SKP-01

ADDENDUM #1	
TRENCH DRAIN DEMOLITION	
DETENTION AREA RENOVATIONS	
CUMBERLAND COUNTY COURTHOUSE	
Scale: 1/4" = 1'-0"	Project No: 04084
Date: 25 OCT 2005	CAD File: 04084P.DWG

E6 PLUMBING DEMOLITION PLAN  
1/4" = 1'-0"

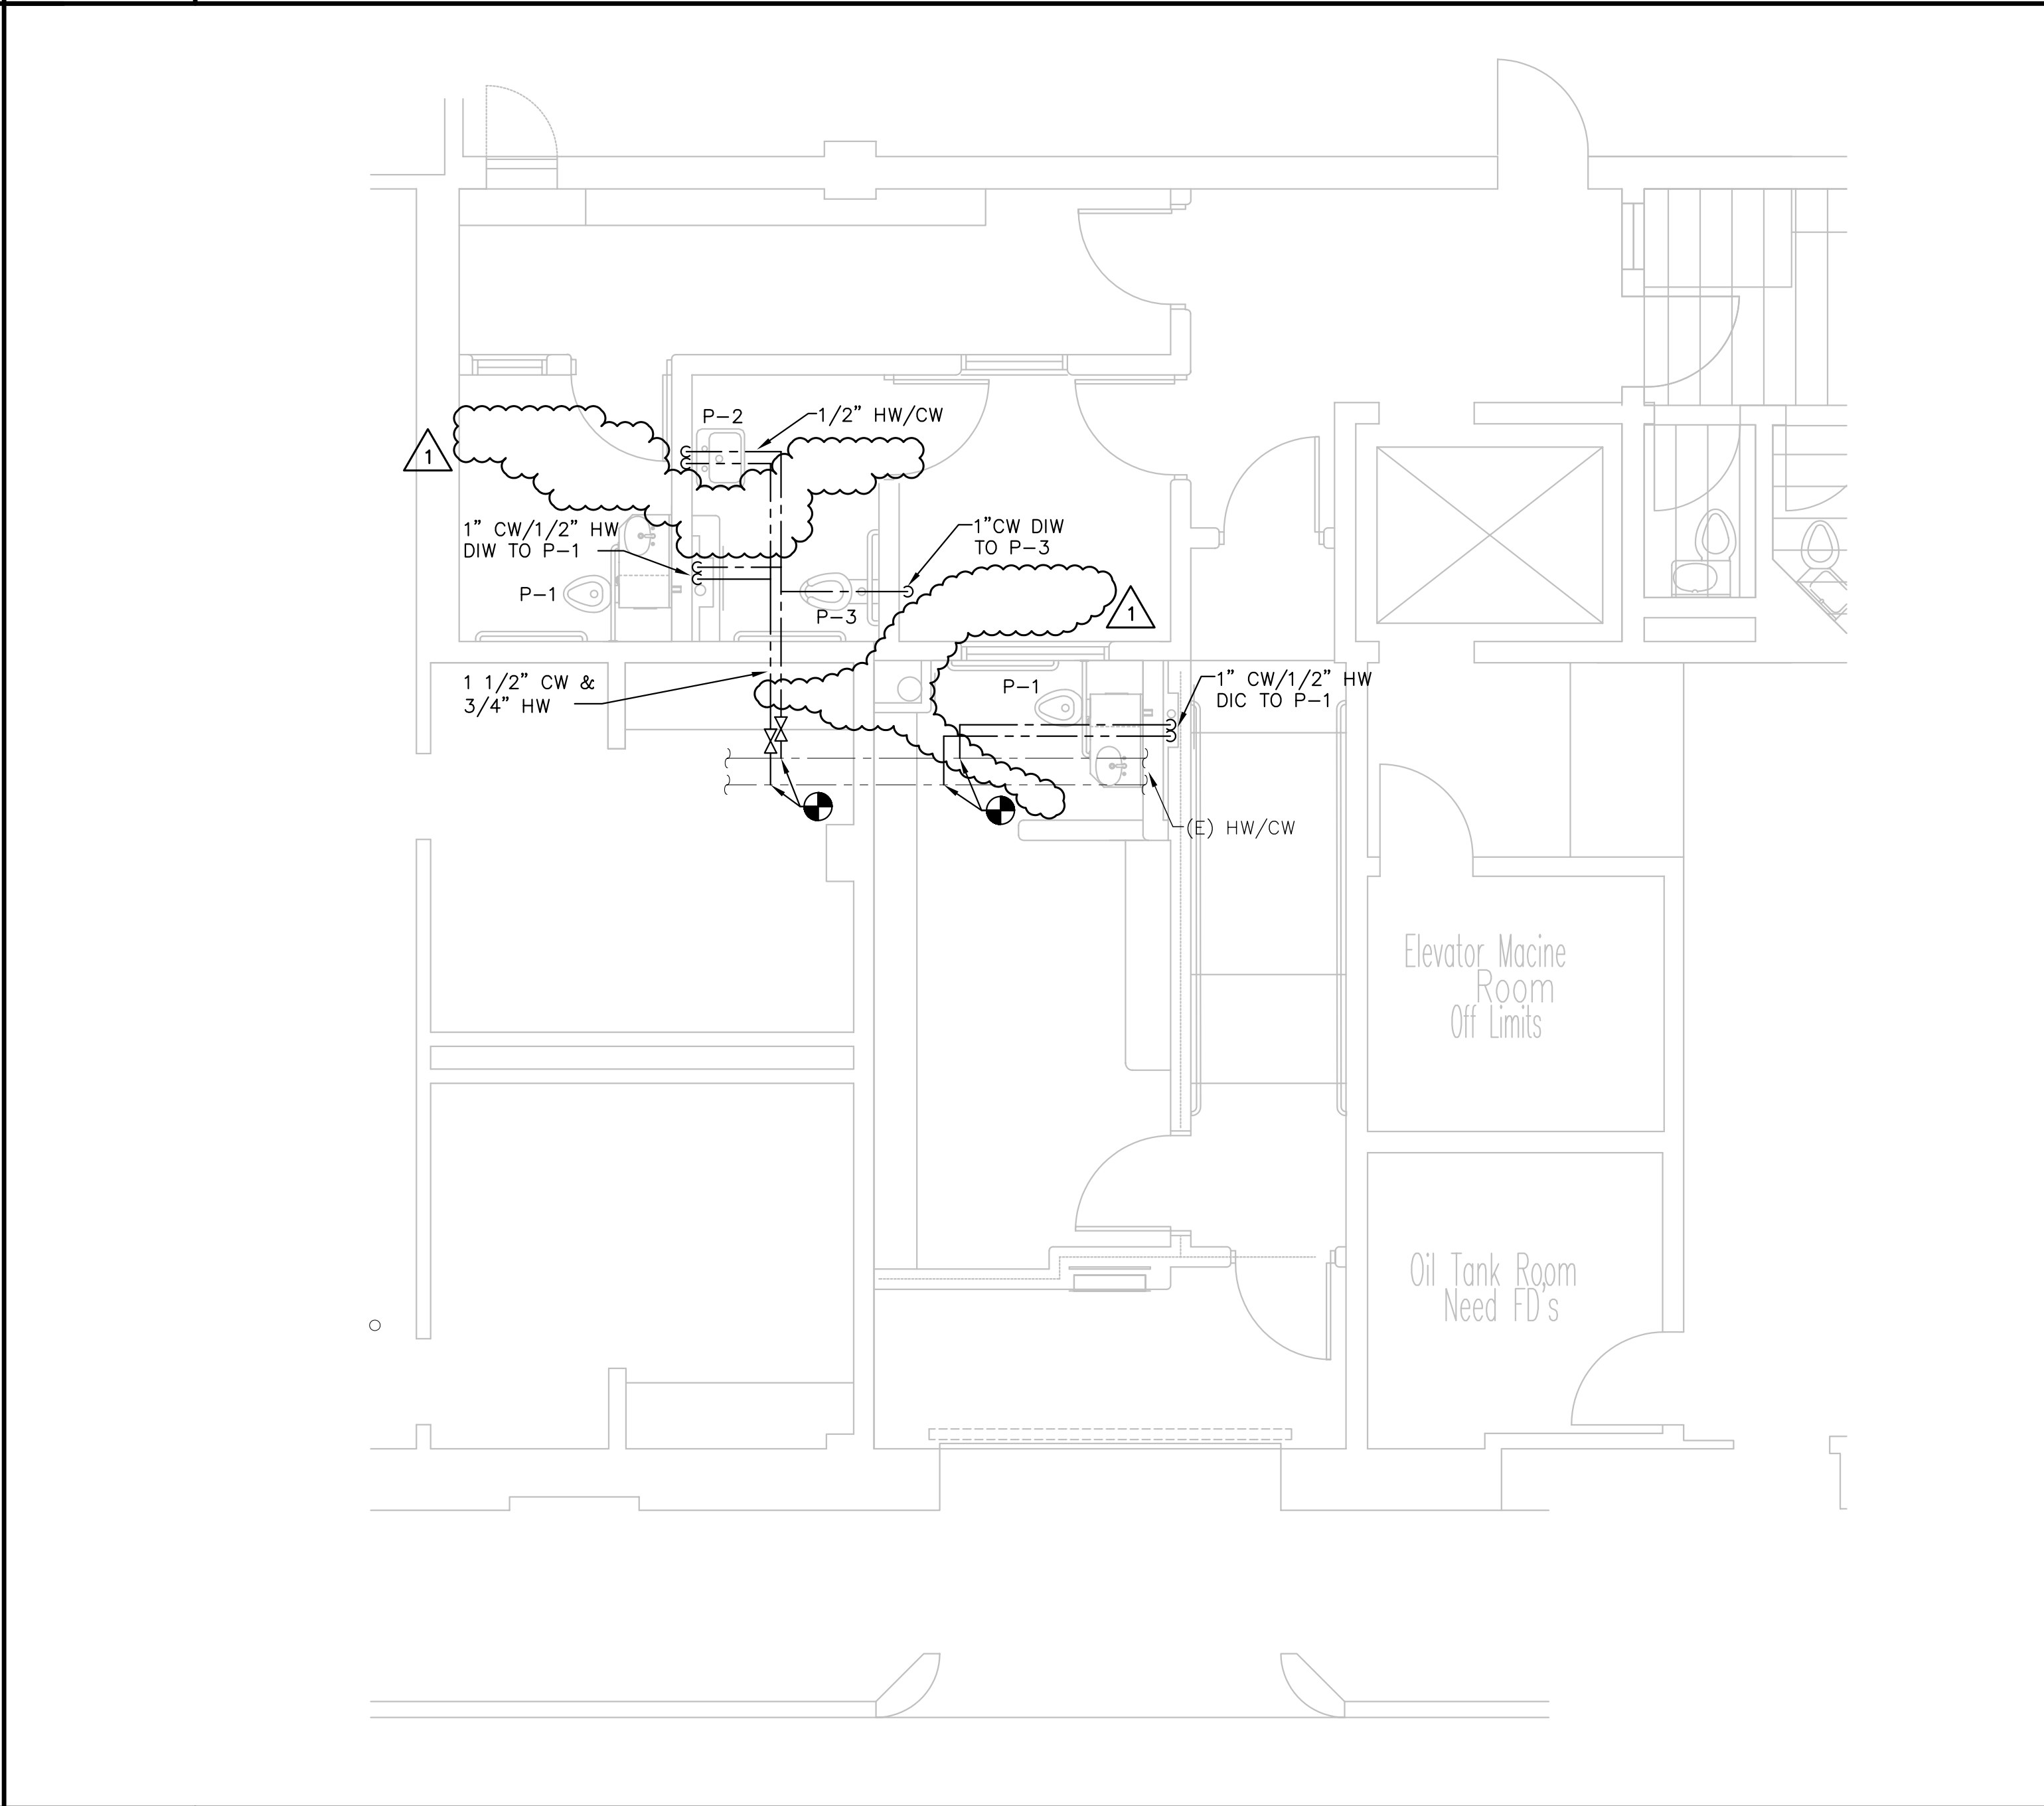
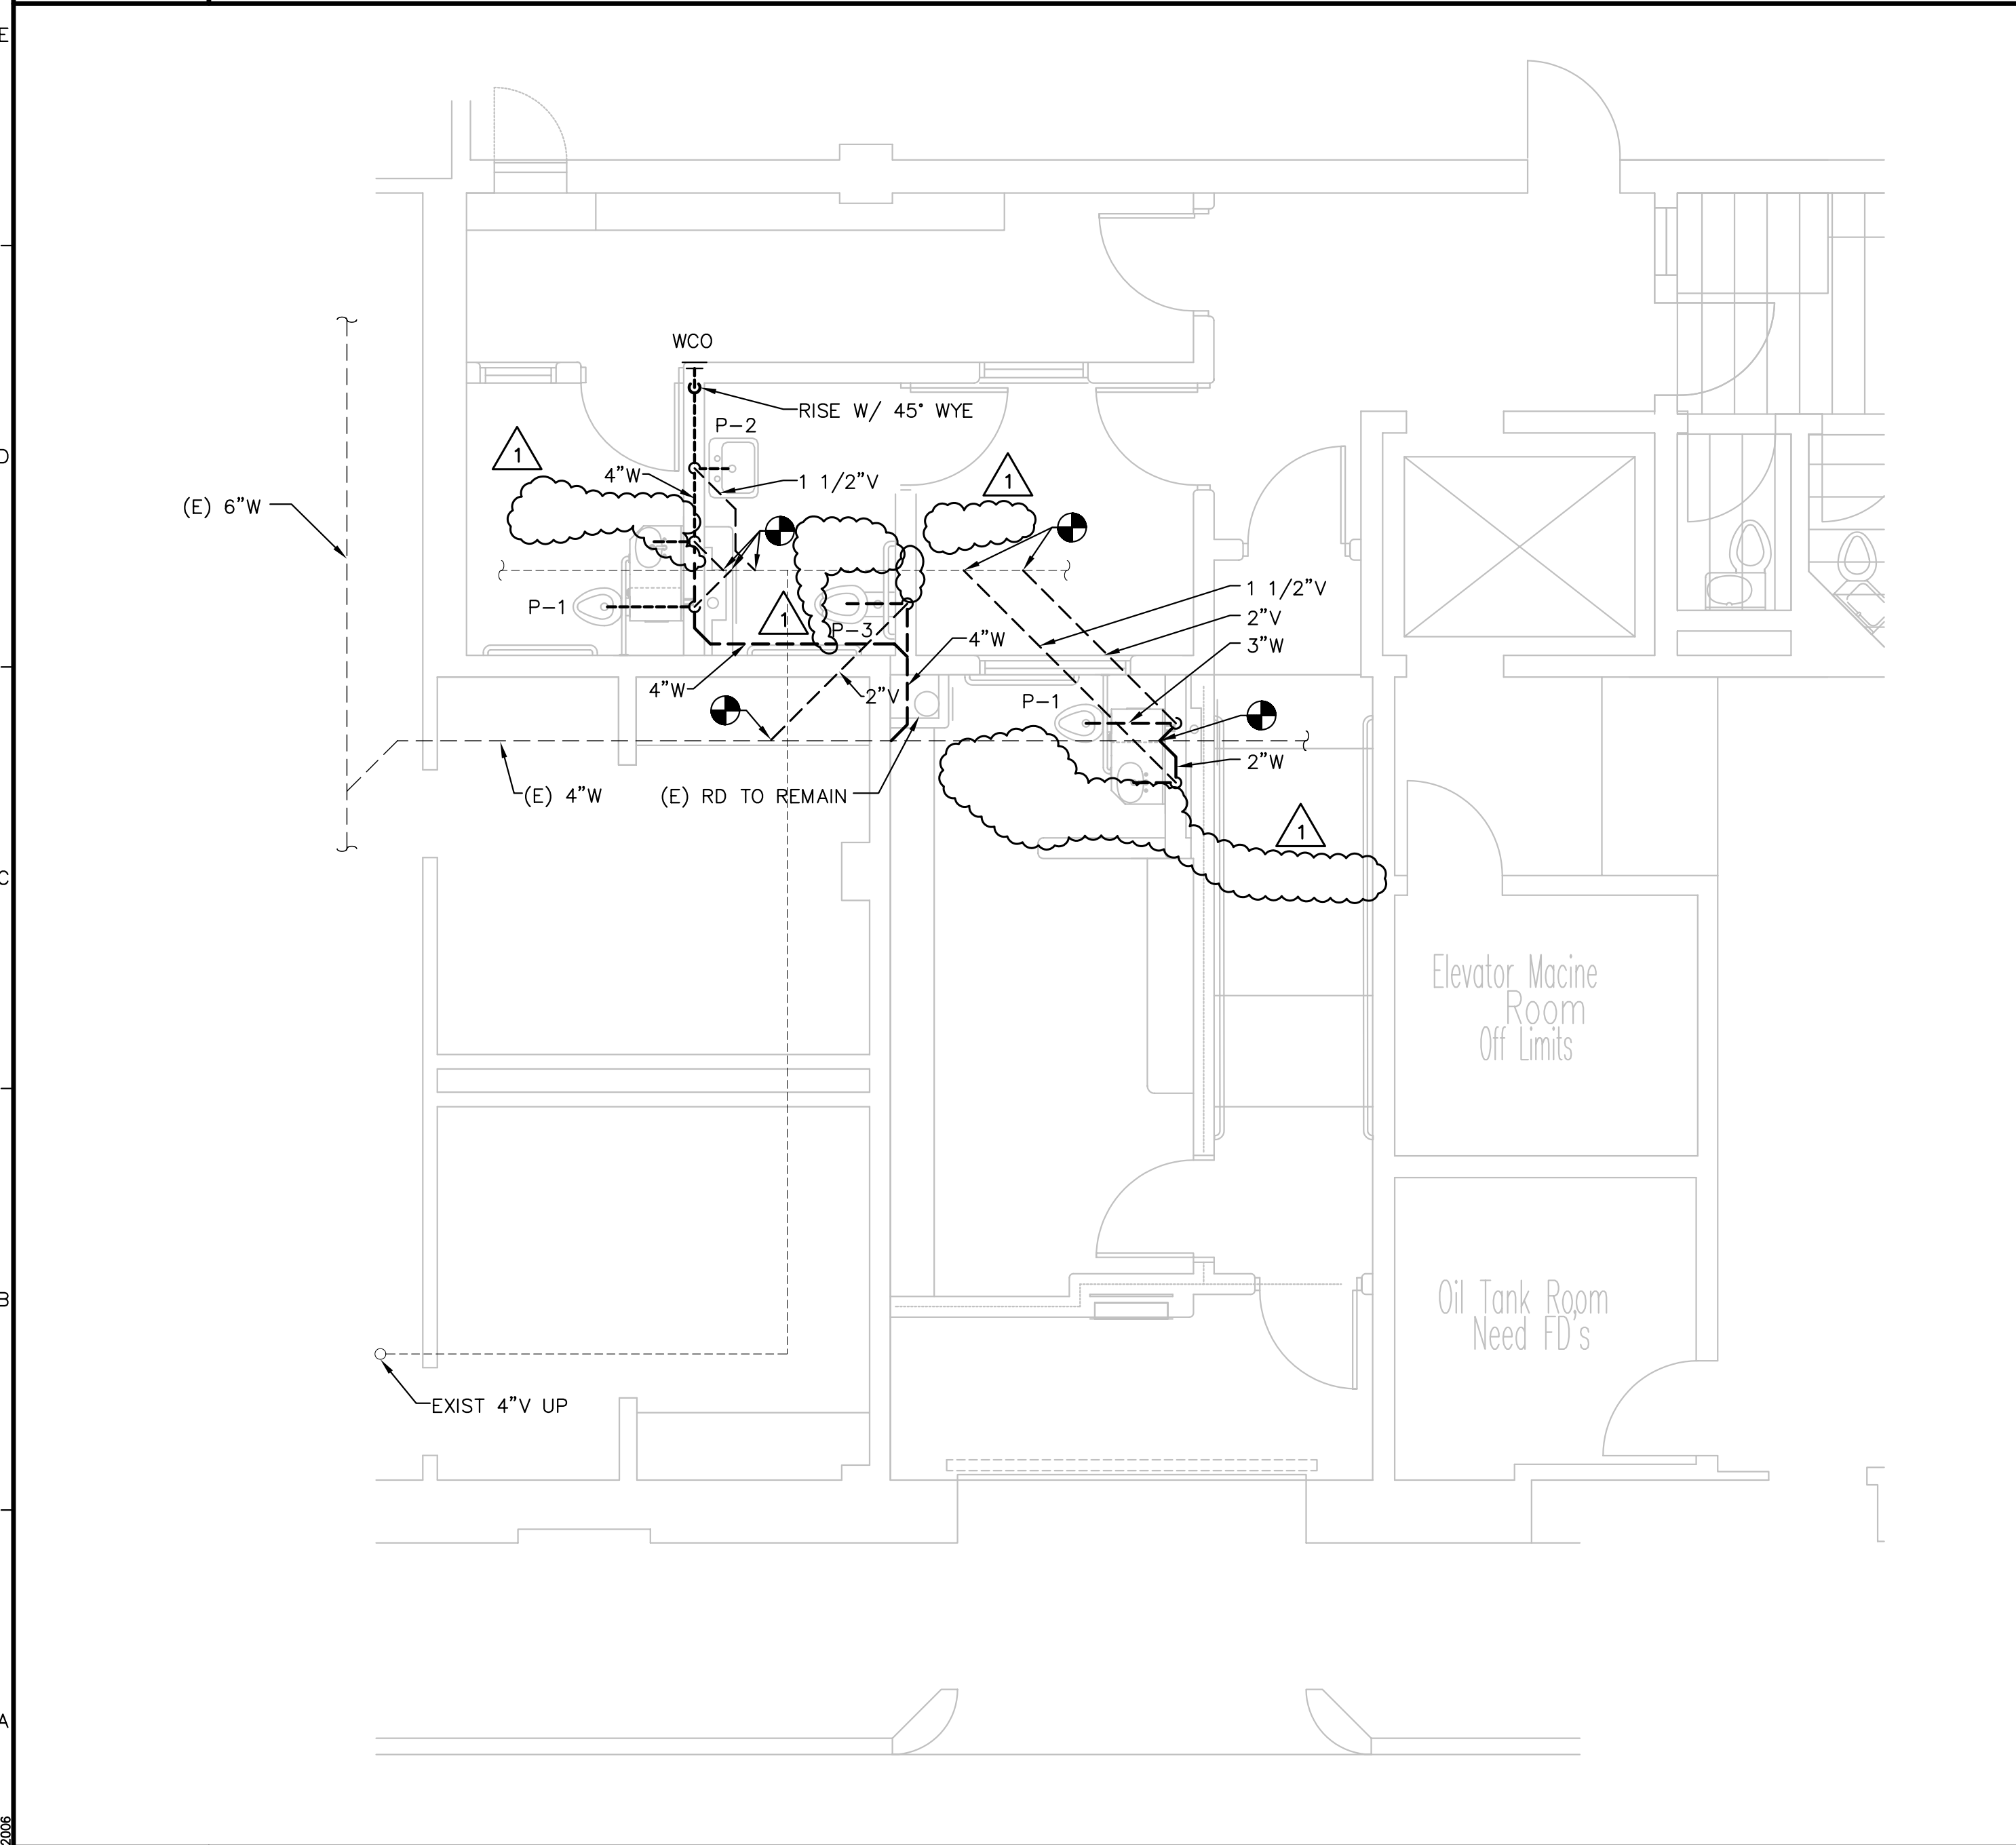
REMOVE (E) TRENCH
DRAIN COMPLETE. CAP
(E) WASTE BFF.
